From: Laura Gibbons
Sent: 20 December 2018 11:56
To: Planning.Responses
Subject: RE: Planning Consultation on Y/92/18/DOC

Engineers Comments Regarding Conditions 8, 9 and 10

APPLICATION NO: Y/92/18/DOC

Site Address: Land at Long Acre Maypole Lane Yapton

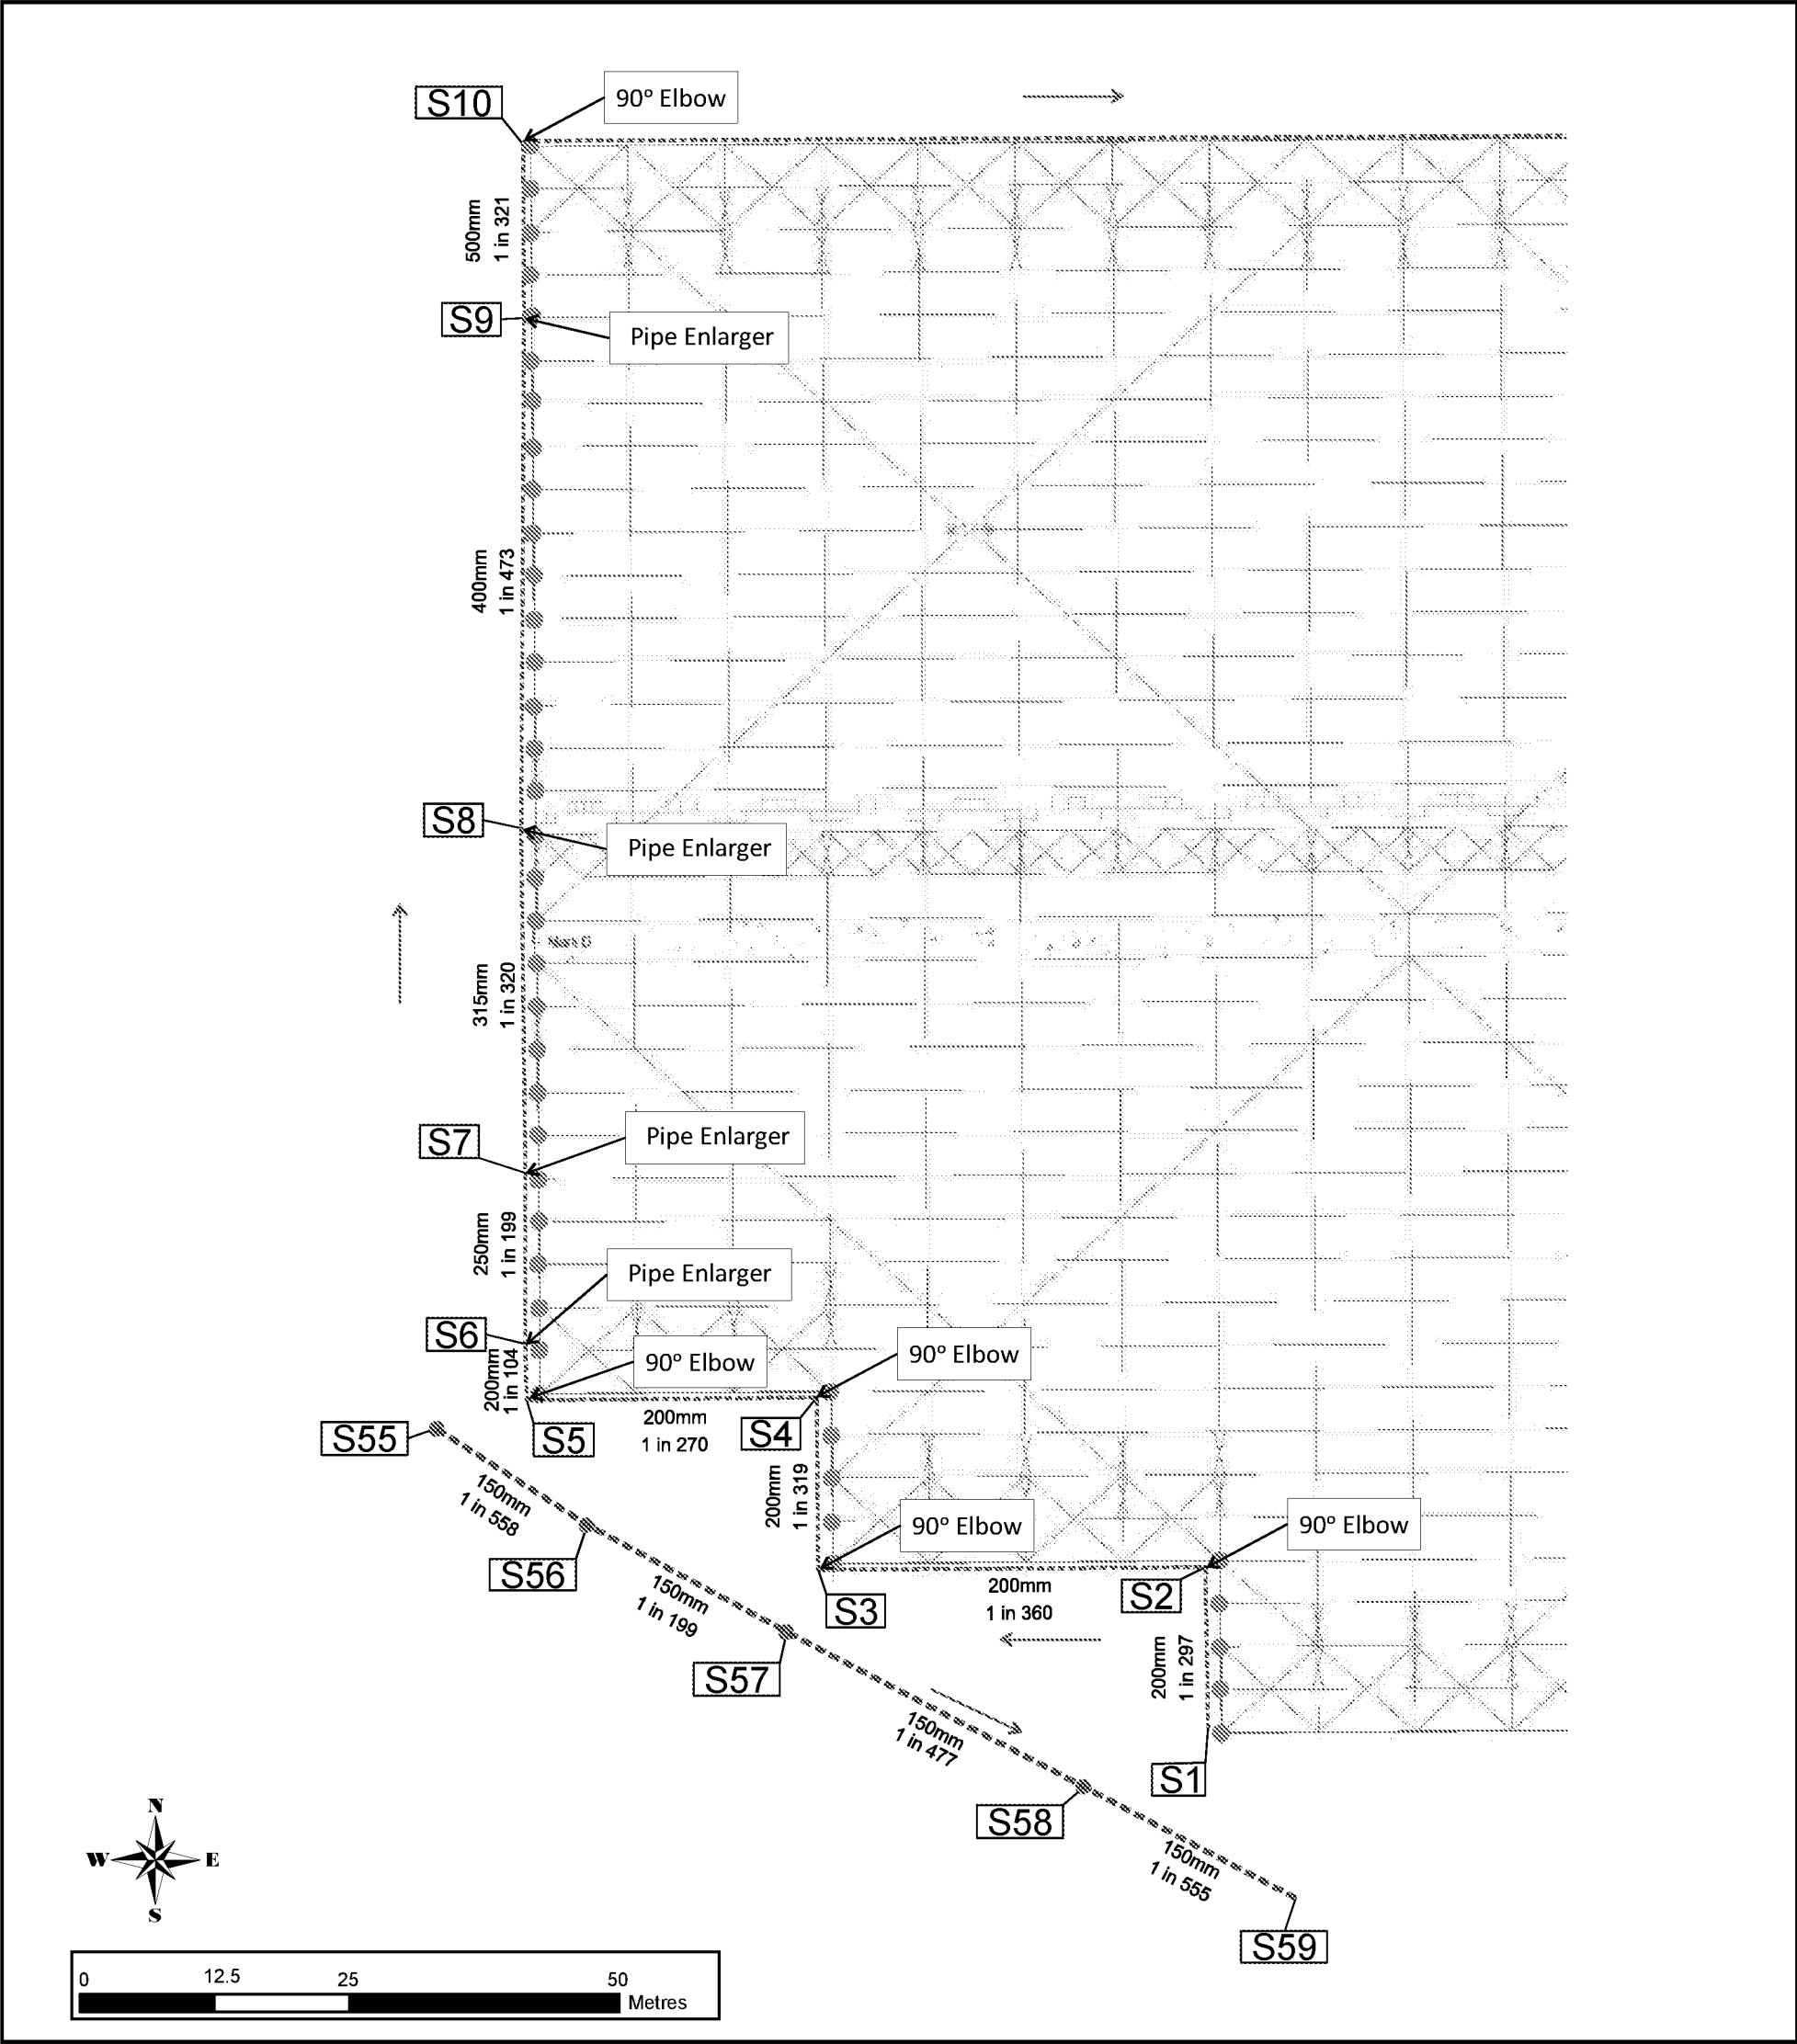
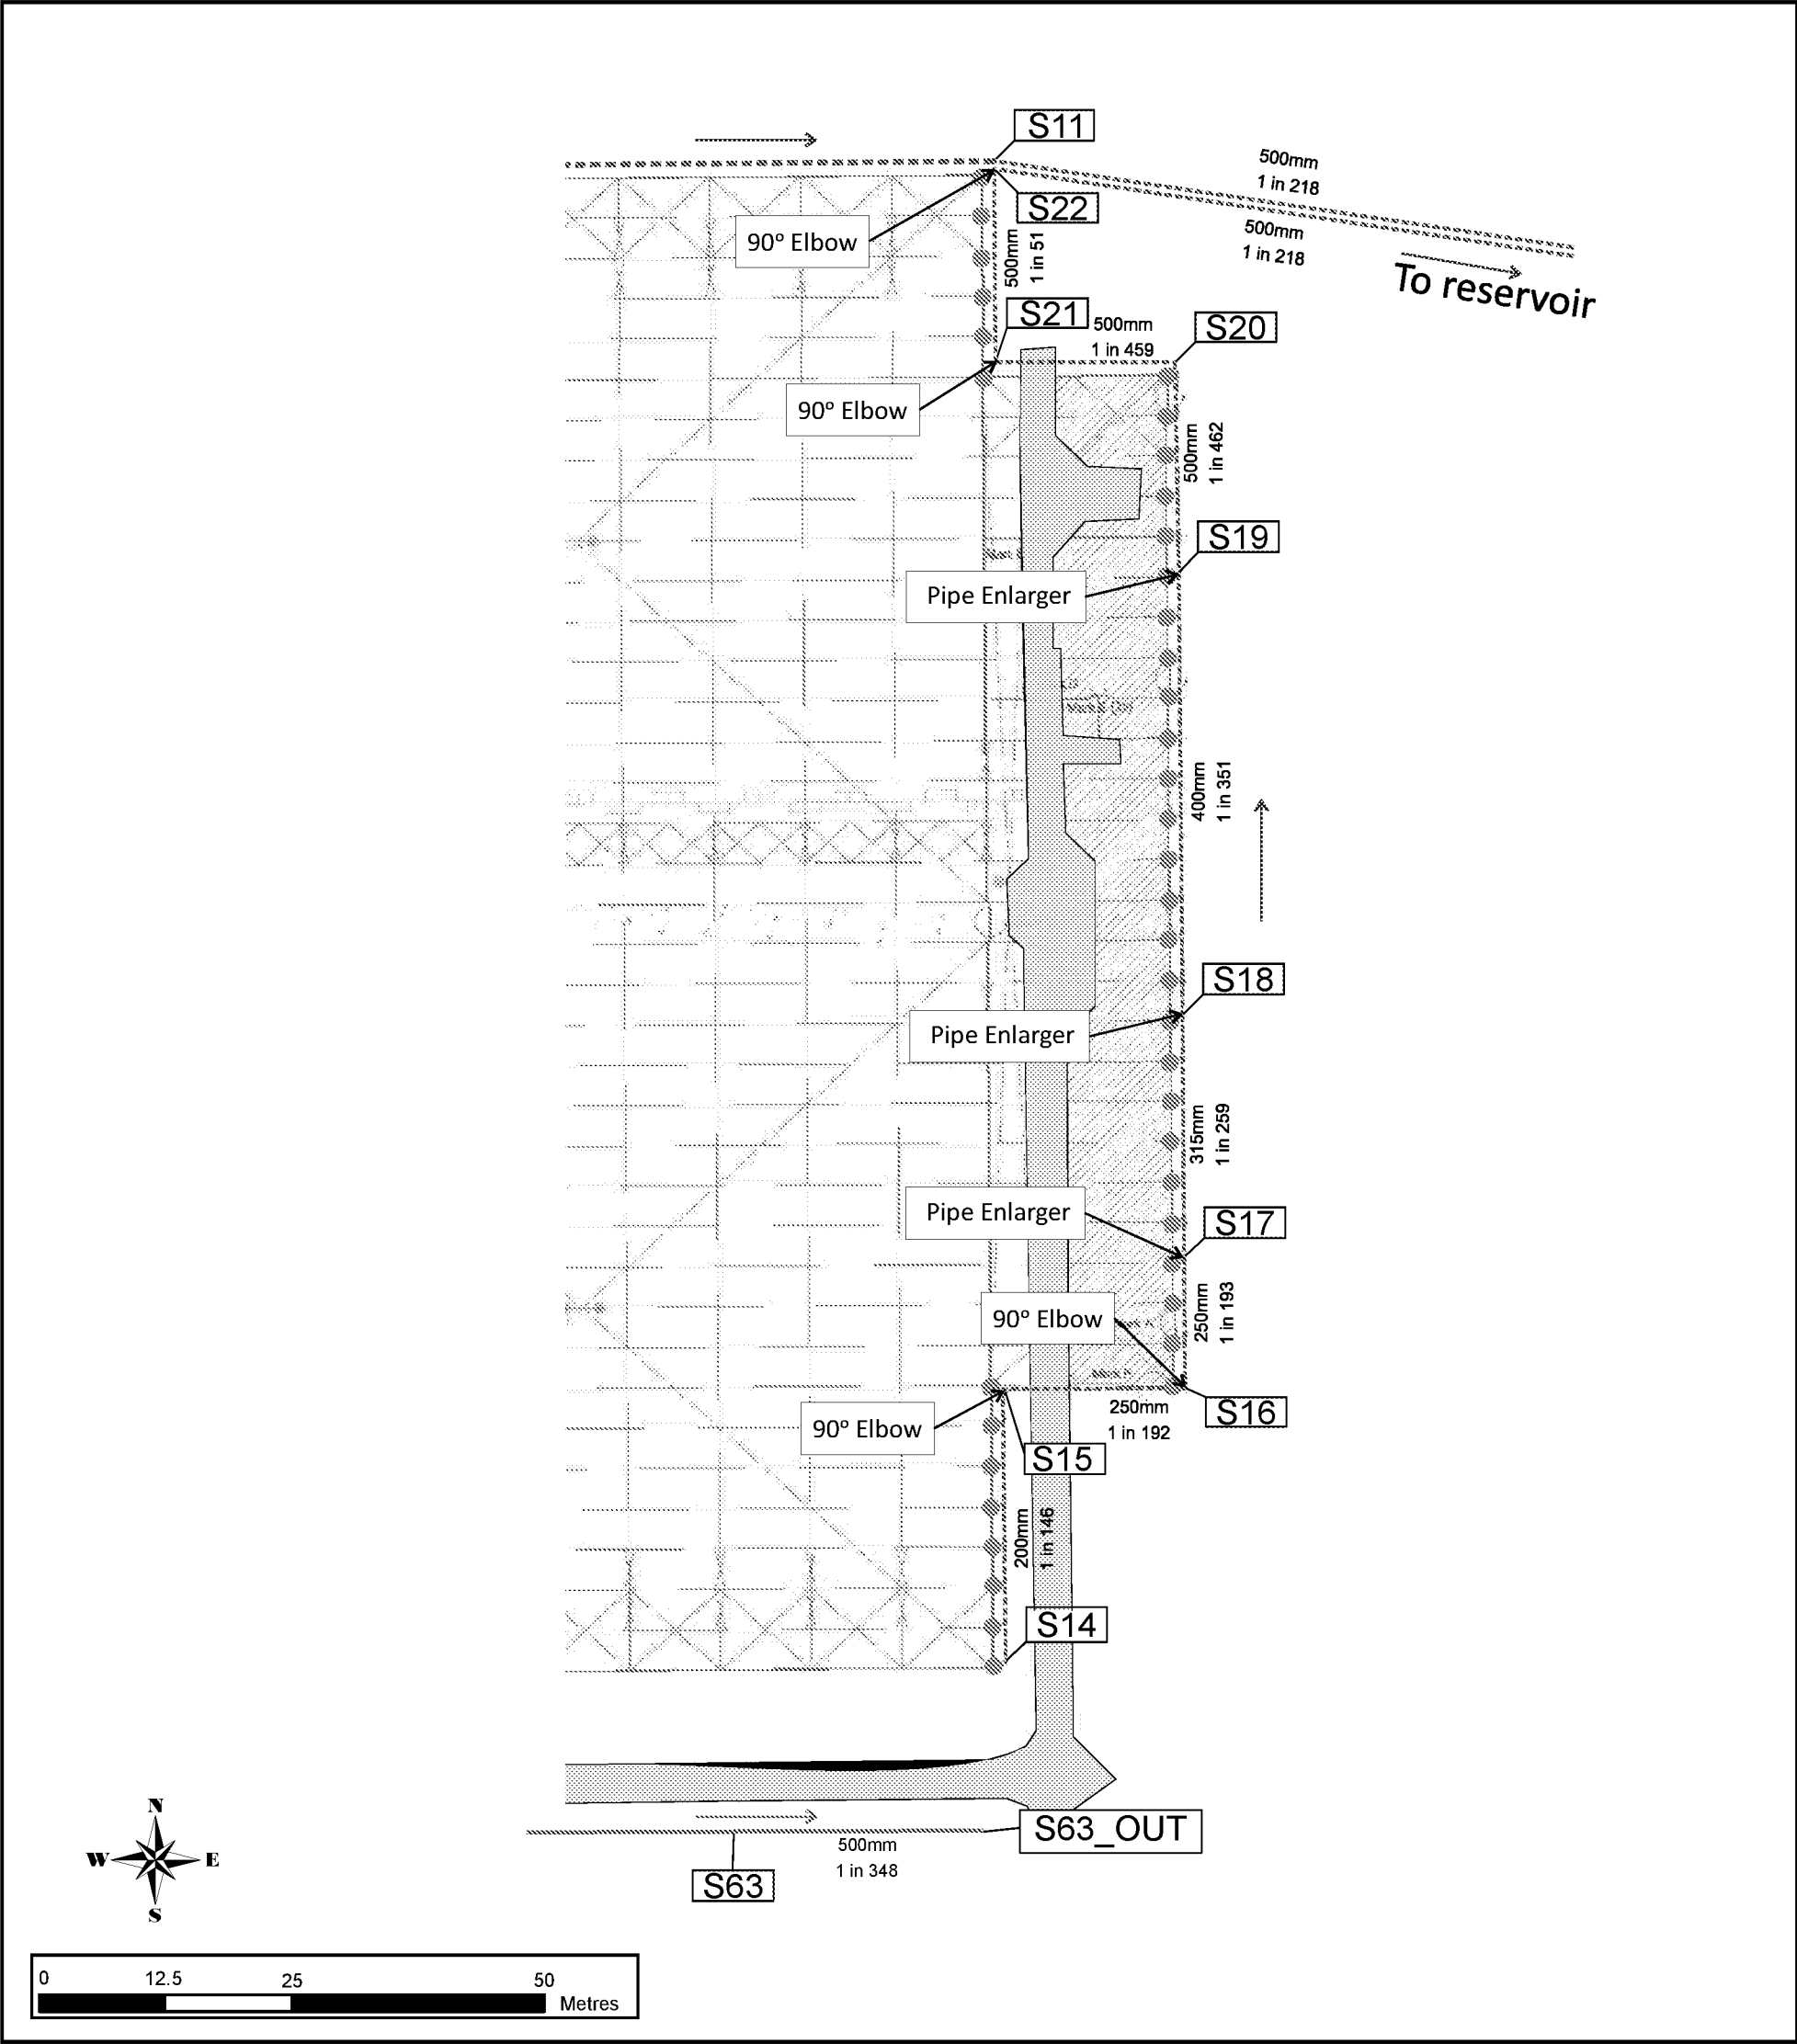
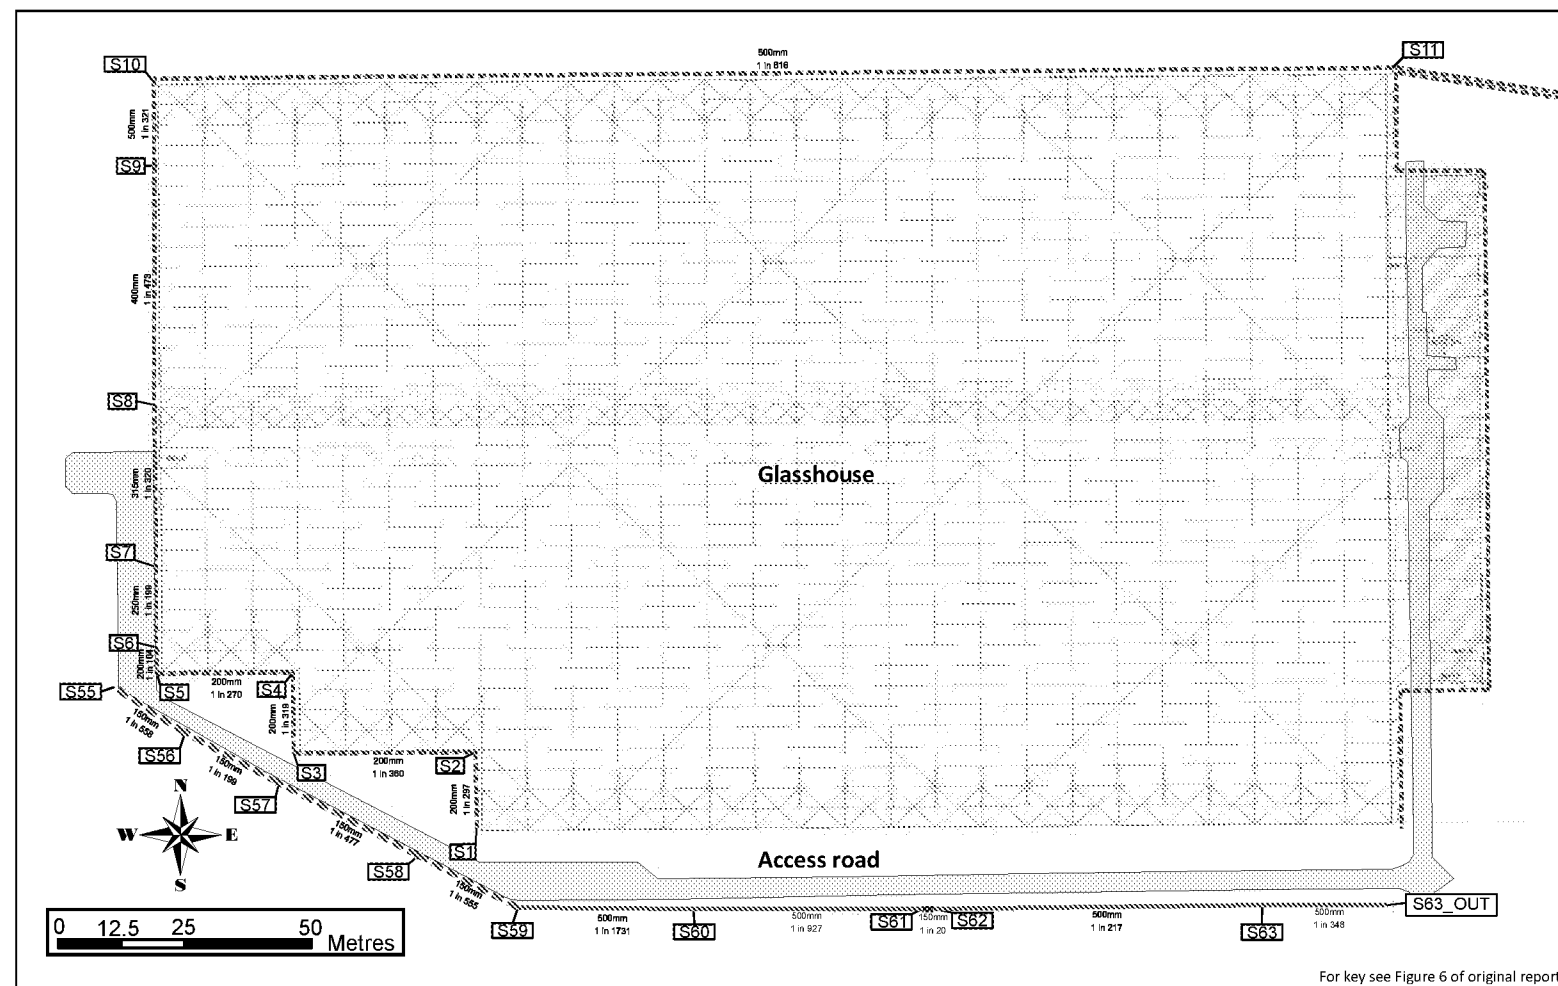
13. Layout plans need to show: slopes, diameters and materials of pipes; cover levels and invert levels of all manholes and silt traps; base levels and bank levels of all swales; overflow levels; etc. I.e. they need to be of a construction standard.
